From: Thomas Callaway
Sent: 08 July 2014 11:49
To: Planning.Responses
Subject: RE: Planning Consultation on: LU/177/14/PL

Engineers comments in respect to surface water drainage:

Site Address: The Old Dairy Behind 3 & 5 Church Street Littlehampton BN17
5EL

Description of Works: Demolition of original dairy distribution depot and construction of 8No. dwellings and ancillary works. Resubmission following LU/298/13. This application may affect the Character and Appearance of the Littlehampton (East Street) Conservation Area.

SITE PLAN WITH DRAFT LEVELS
 PROPOSED RESIDENTIAL DEVELOPMENT
 THE OLD DAIRY, CHURCH STREET, LITTLEHAMPTON, SUSSEX.
 GRAHAM NICOLLS LIMITED, DESIGN + TECHNOLOGY, TEL/07990 522709

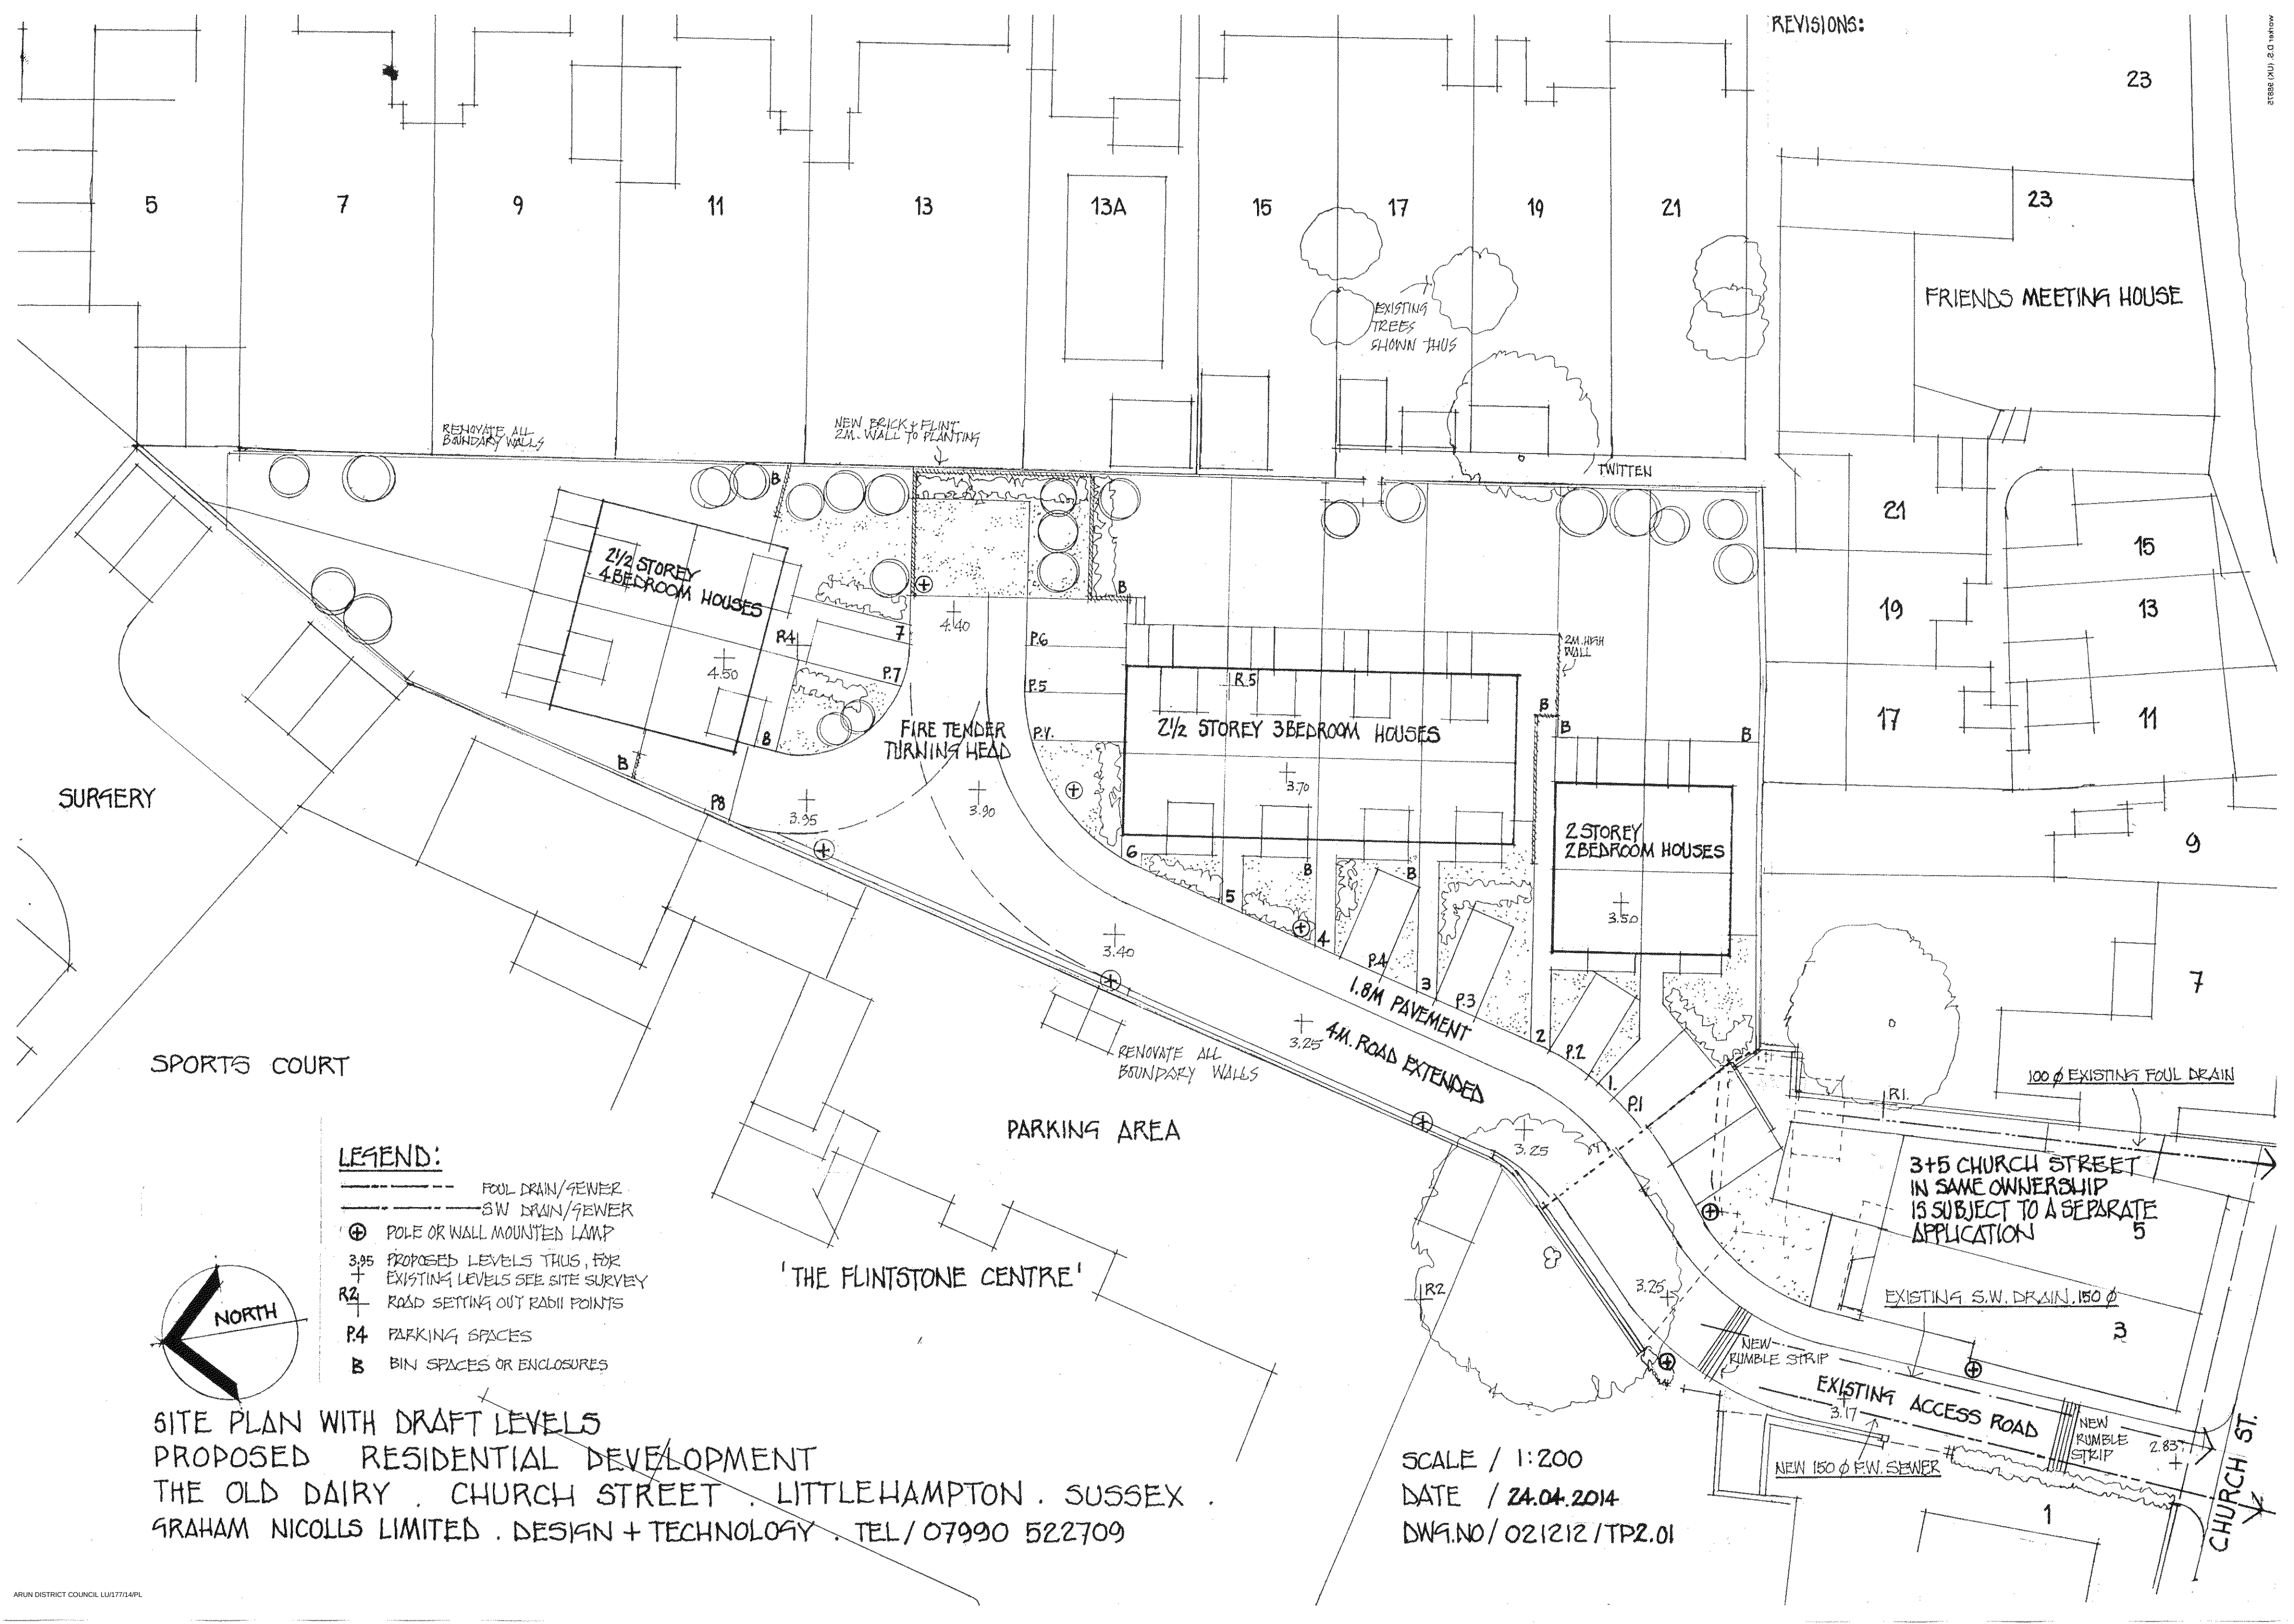
The applicant previously stated that surface water will be allowed to infiltrate into the ground, using Sustainable Drainage Systems such as permeable paving. This should be prioritised over the proposal stating that surface water will be disposed of through the main sewer, which should be avoided.

Infiltration rates for soakage structures are to be based on percolation tests undertaken in the winter period and at the location and depth of the proposed structures. The percolation tests and design must be carried out in accordance with BRE 365, CIRIA R156 or a similar approved method and cater for the 1 in 10 year storm between the invert of the entry pipe to the soakaway, and the base of the structure. It must also have provision to ensure that there is capacity in the system to contain below ground level the 1 in 100 year event plus 30% on stored volumes, as an allowance for climate change. Adequate freeboard must be provided between the base of the soakaway structure and the highest recorded annual groundwater level identified in that location.

Any SuDS or soakaway design must include adequate groundwater monitoring data to determine the highest winter groundwater table in support of the design. The applicant is advised to discuss the extent of groundwater monitoring with the Council's Engineers. Supplementary guidance notes are also enclosed for information.

Please apply standard conditions ENGD2A and ENGD5A.
